AB/41/21/L

Herricks School Lane Arundel BN18 9DR

Listed building consent for the repair and painting of the exterior walls, doors and windows to the front and rear elevation

HERRICKS – FRONT ELEVATIONS

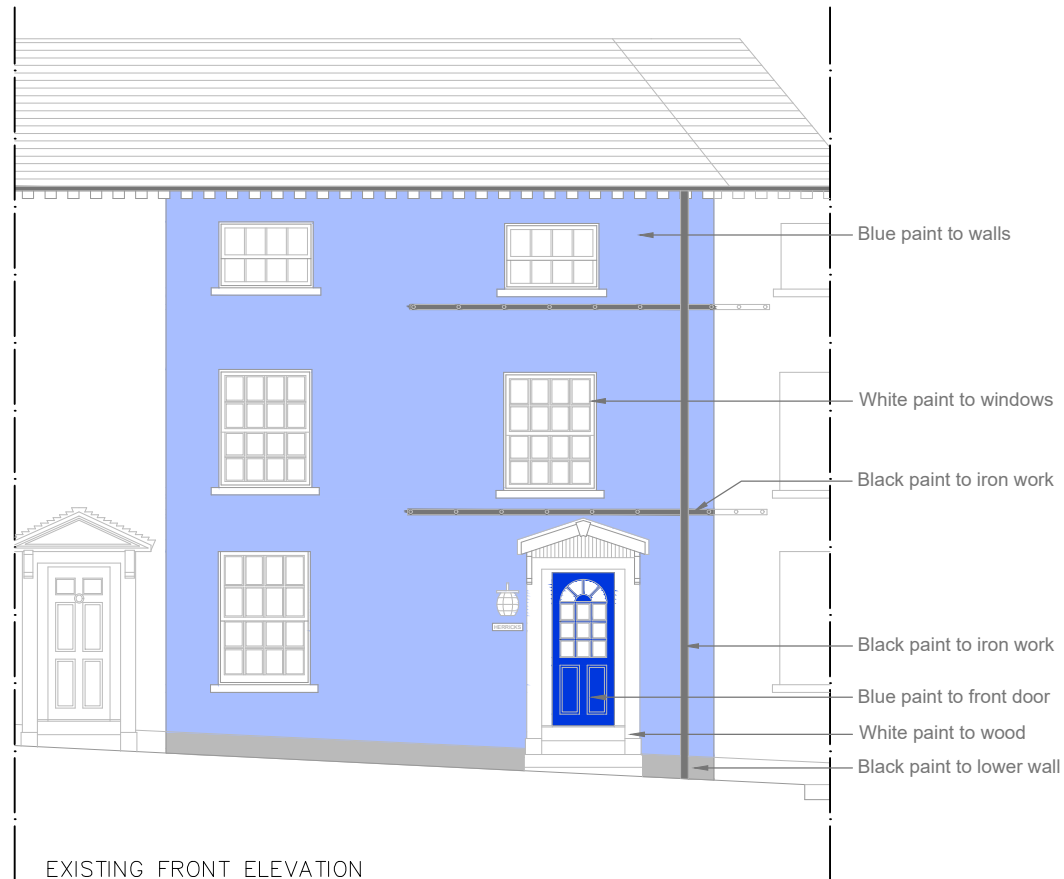
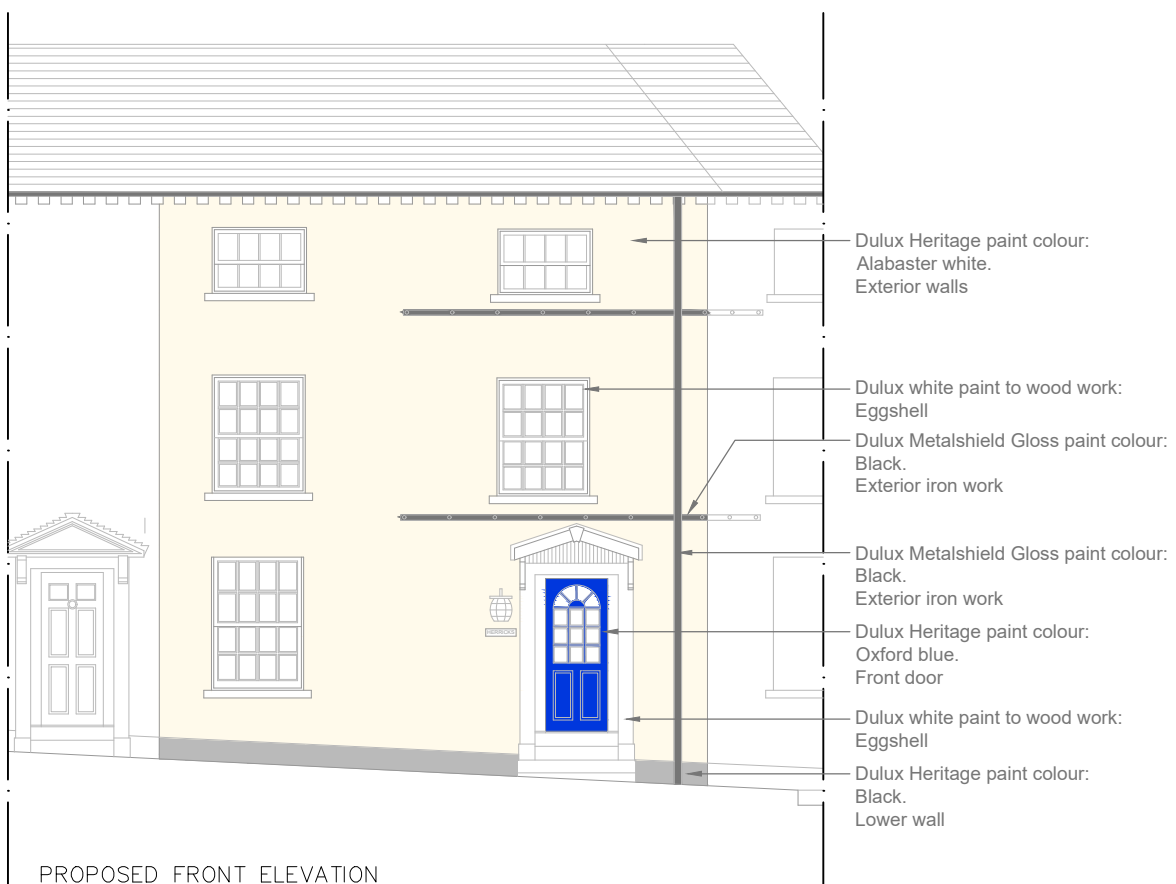
The heritage statement identifies that the front door is currently blue, but that the intention is to paint it black, whereas the Design and Access Statement identifies that it will be painted Oxford Blue. I also note from looking at the plans that the proposed drawing indicates that this door is to be painted Oxford Blue. Whilst either colour would appear to be acceptable, this needs to be clarified.
